# TRAFFIC IMPACT STUDY

## CAP STORAGE FALCON LLC TRAFFIC IMPACT STUDY

El Paso County, Colorado

DATE:  
December 20, 2023

FIGURE 4-2
BACKGROUND GROWTH 2040

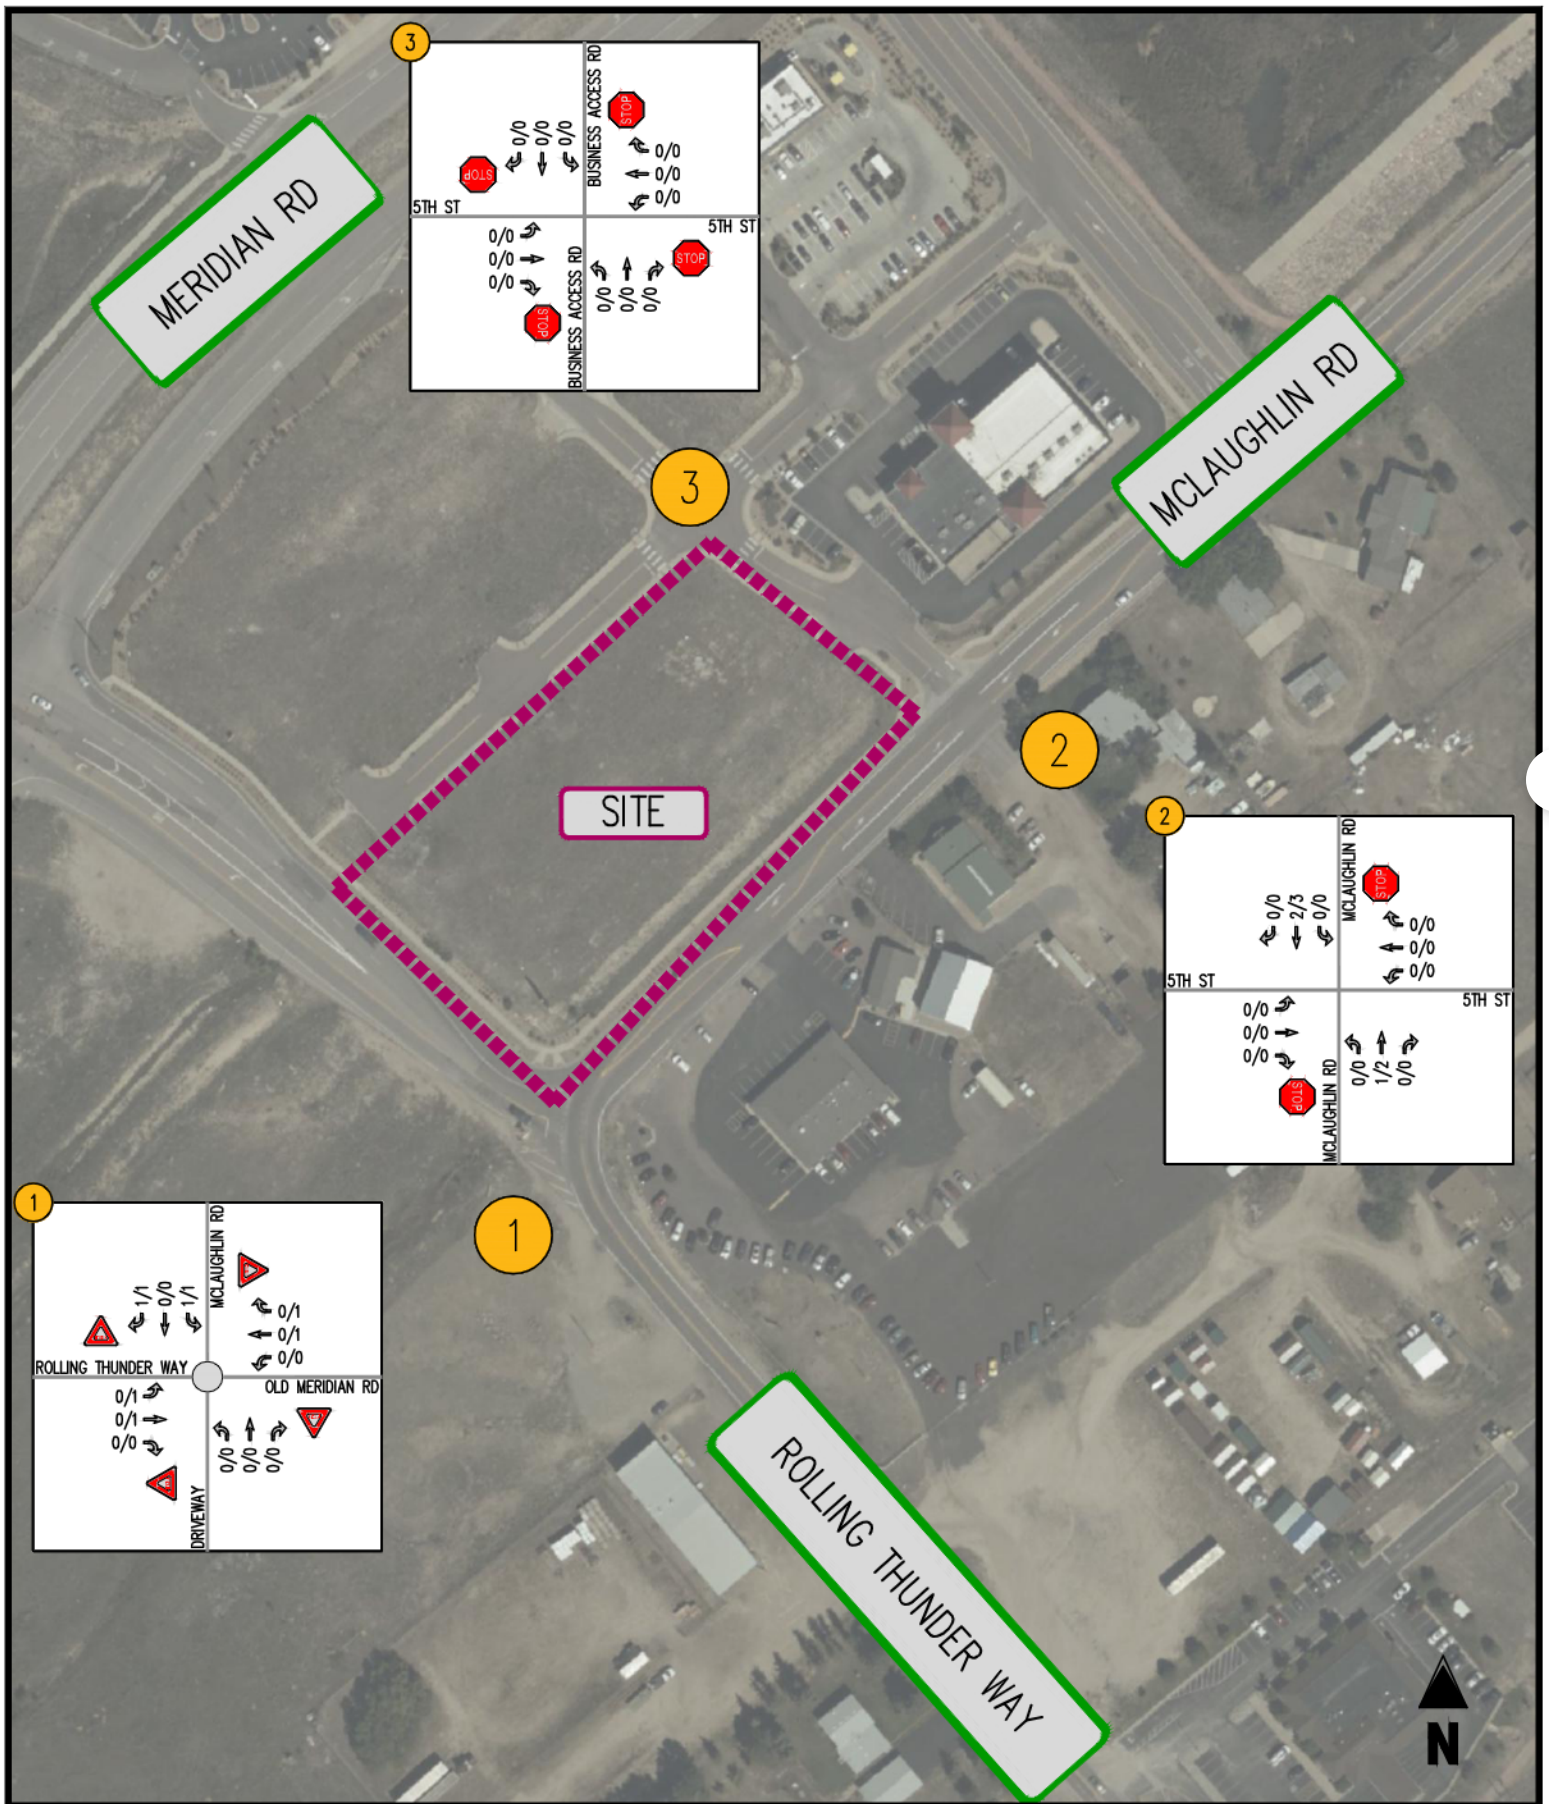
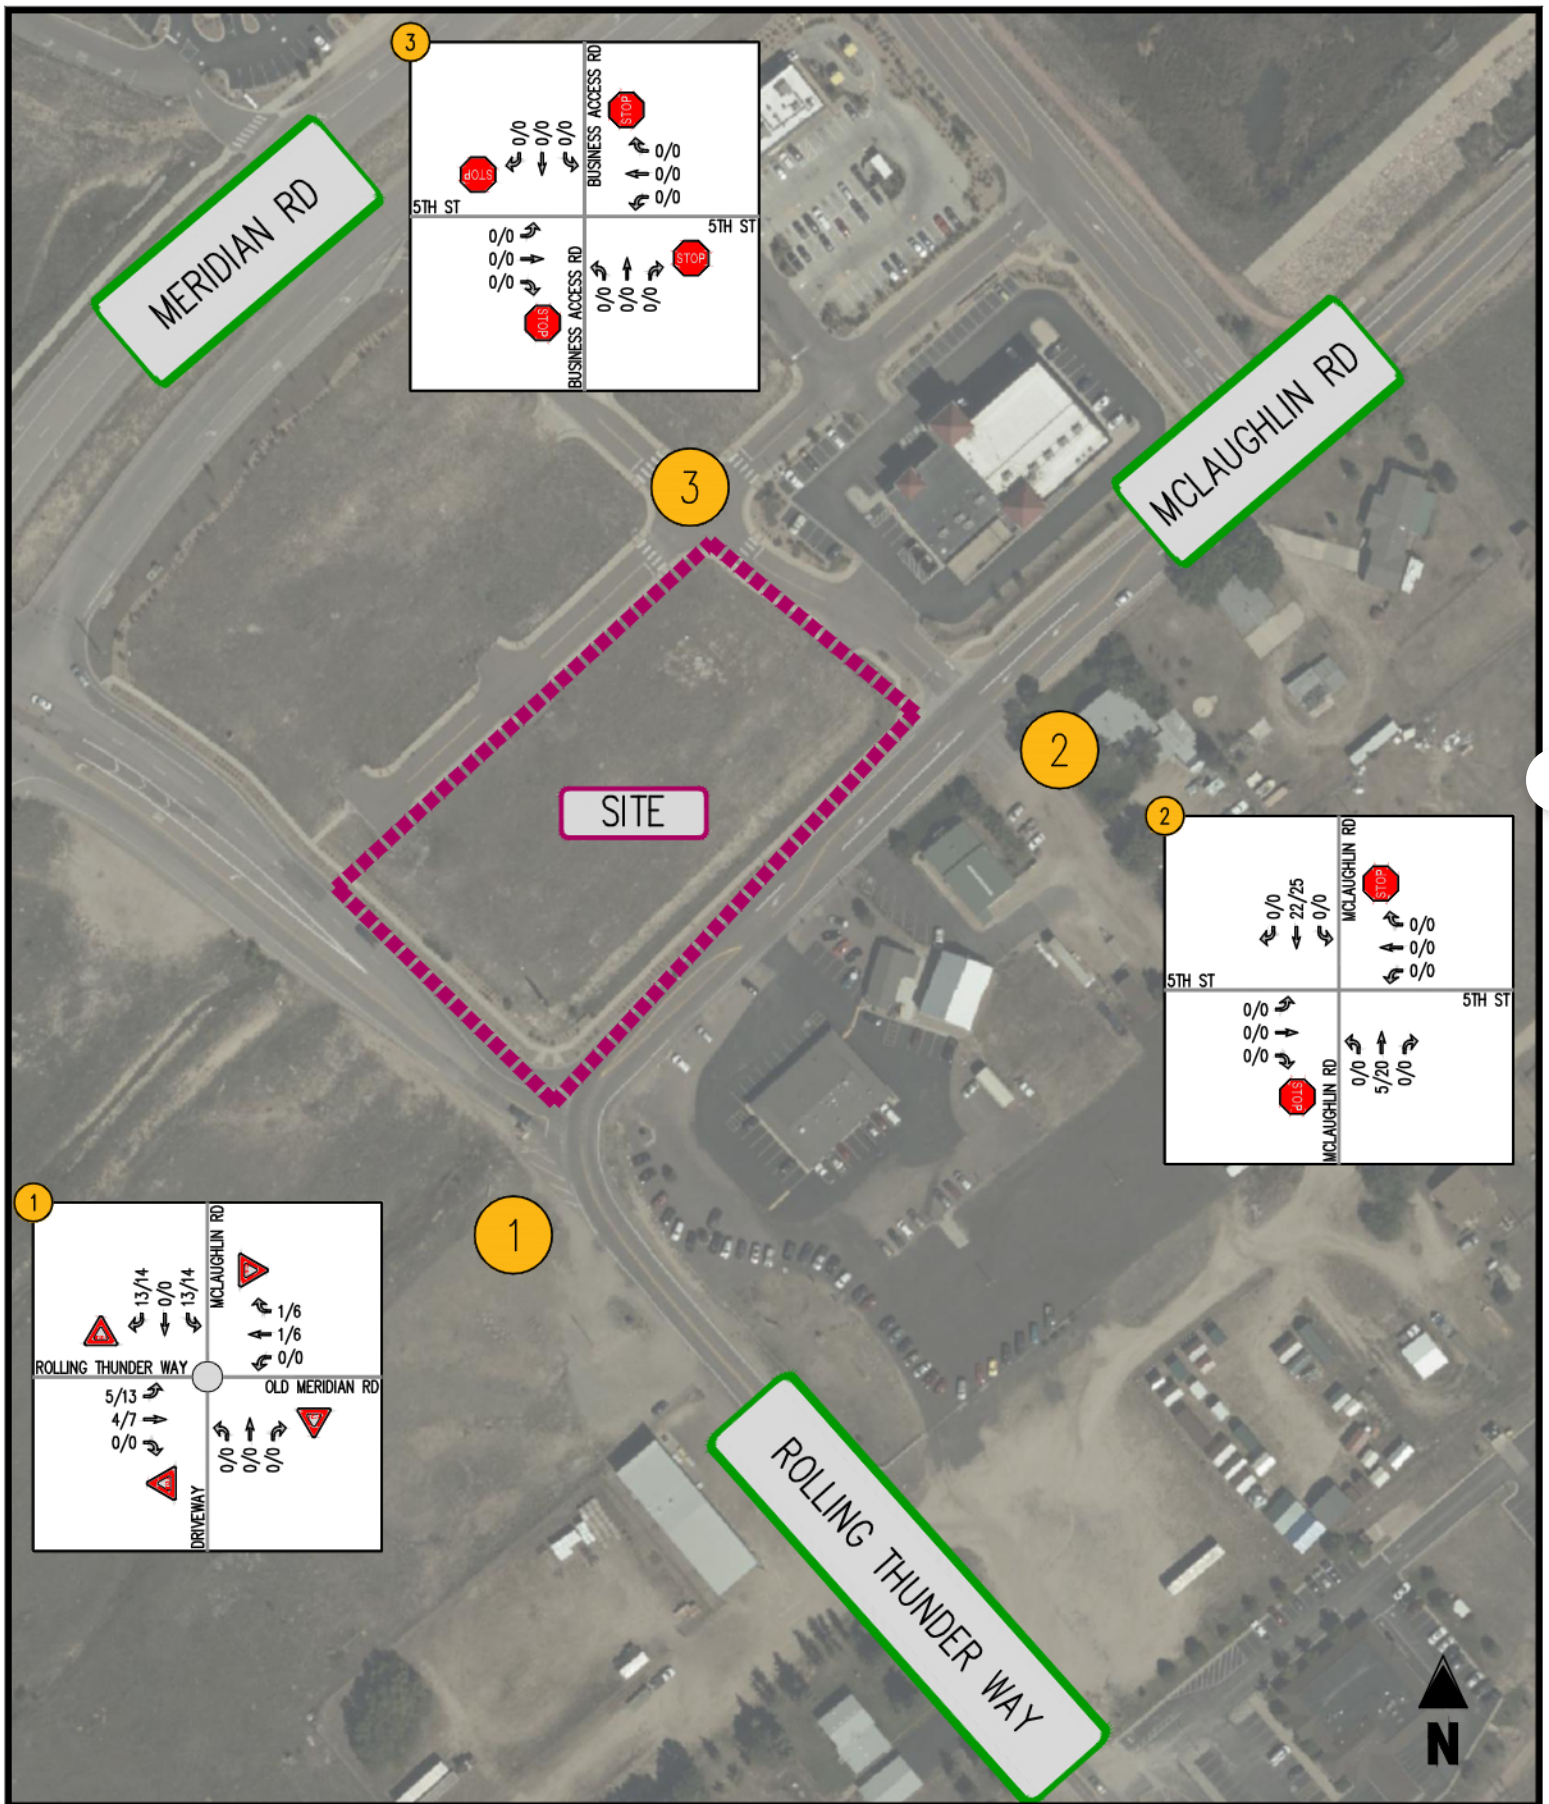
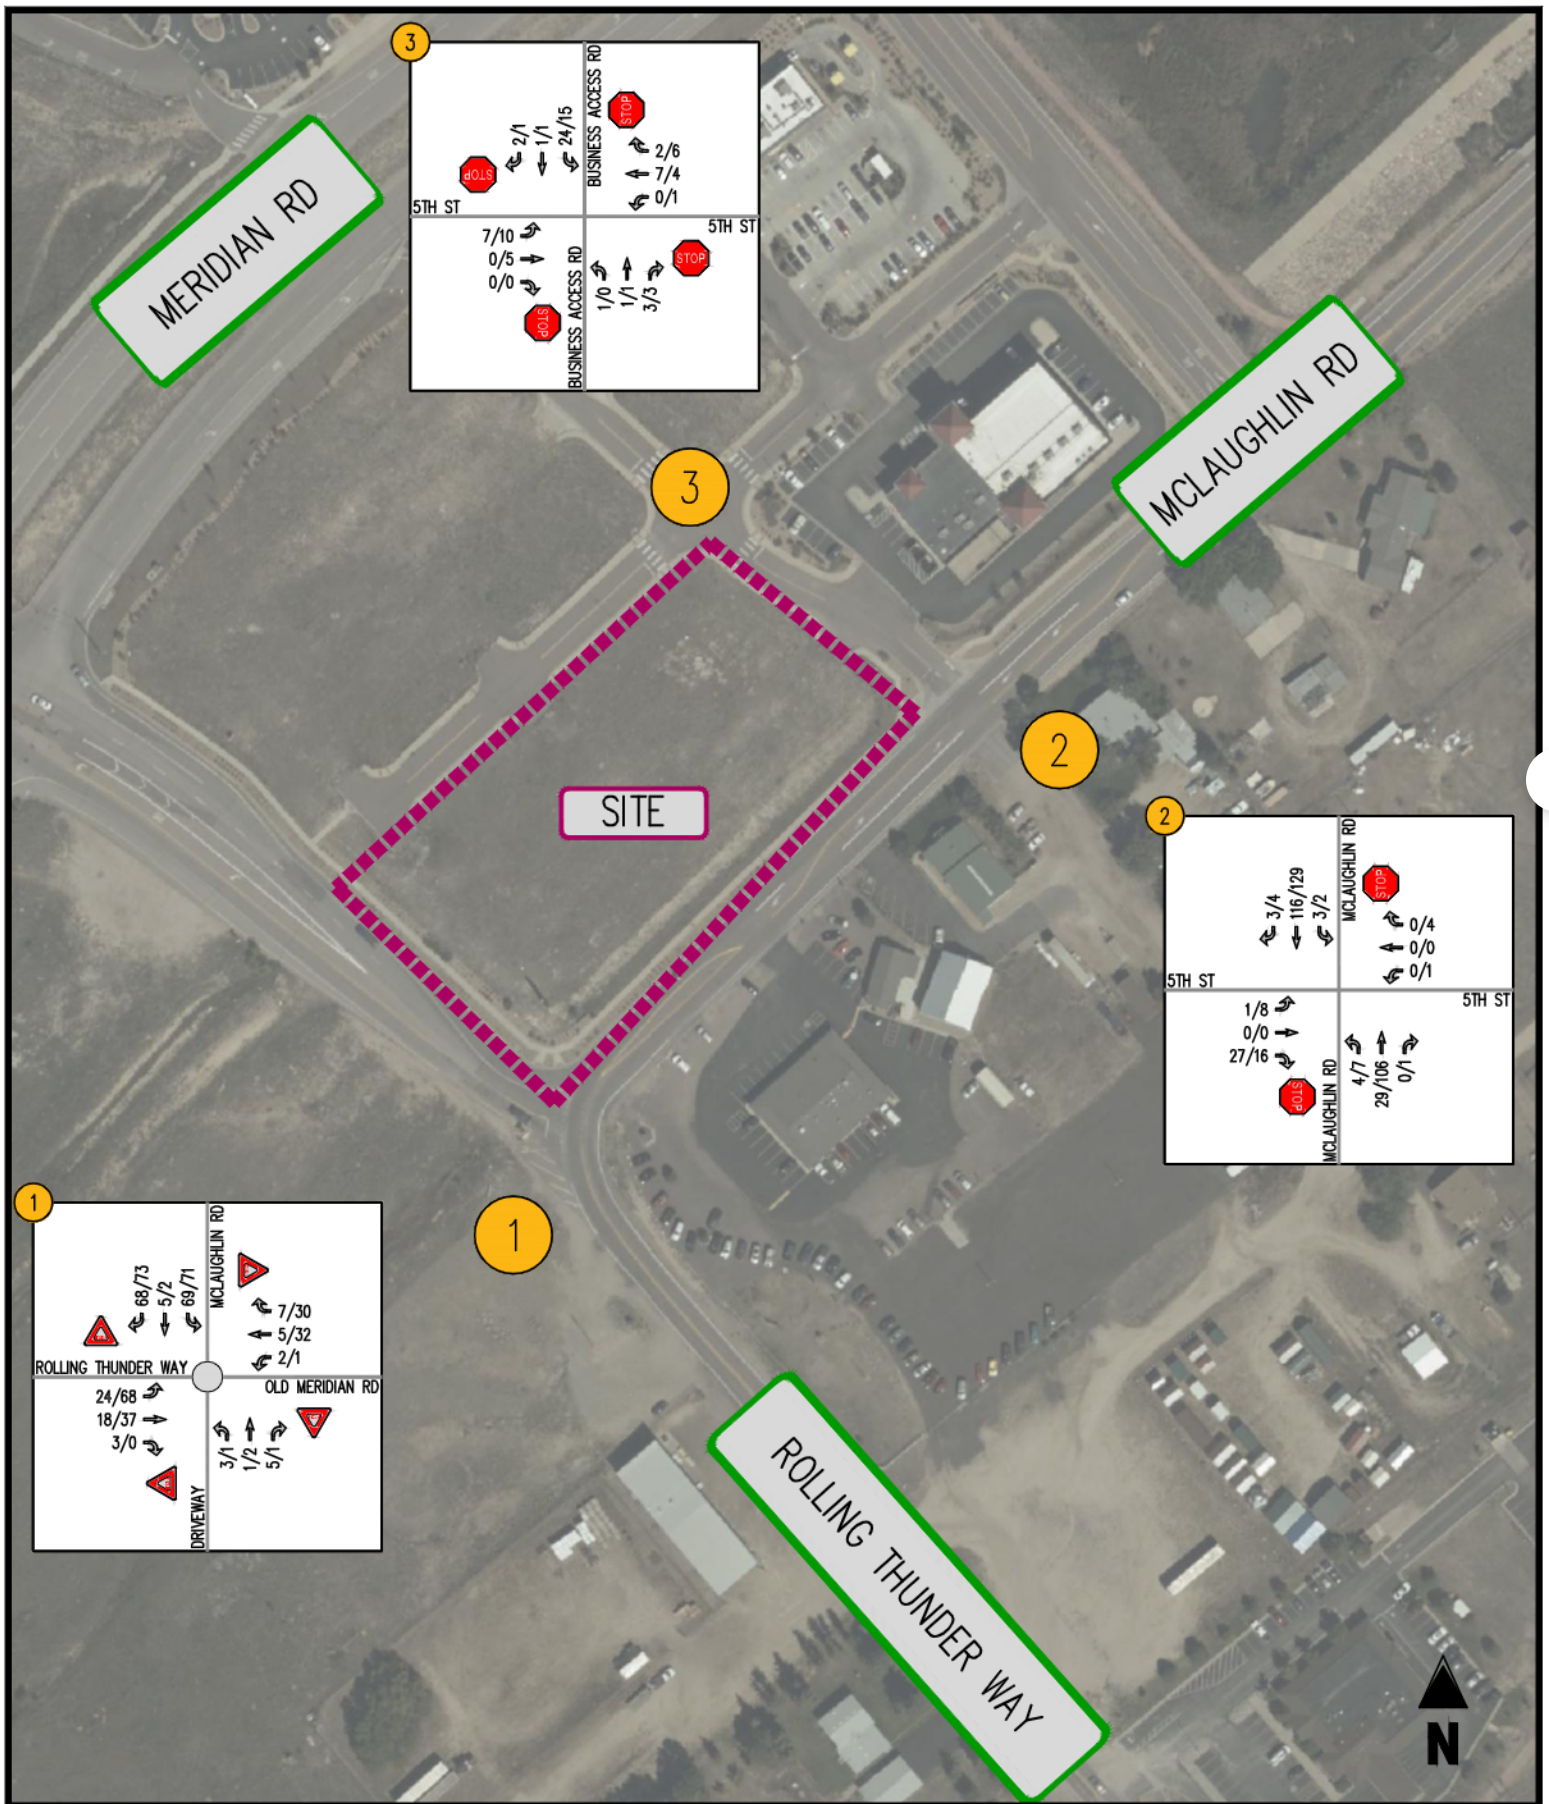
Include long range period for traffic generation and LOS. 2024 is current year. Should see ~2040 See ECM Appdx B Section B.8 Ensure Exhibits are labeled with time horizon
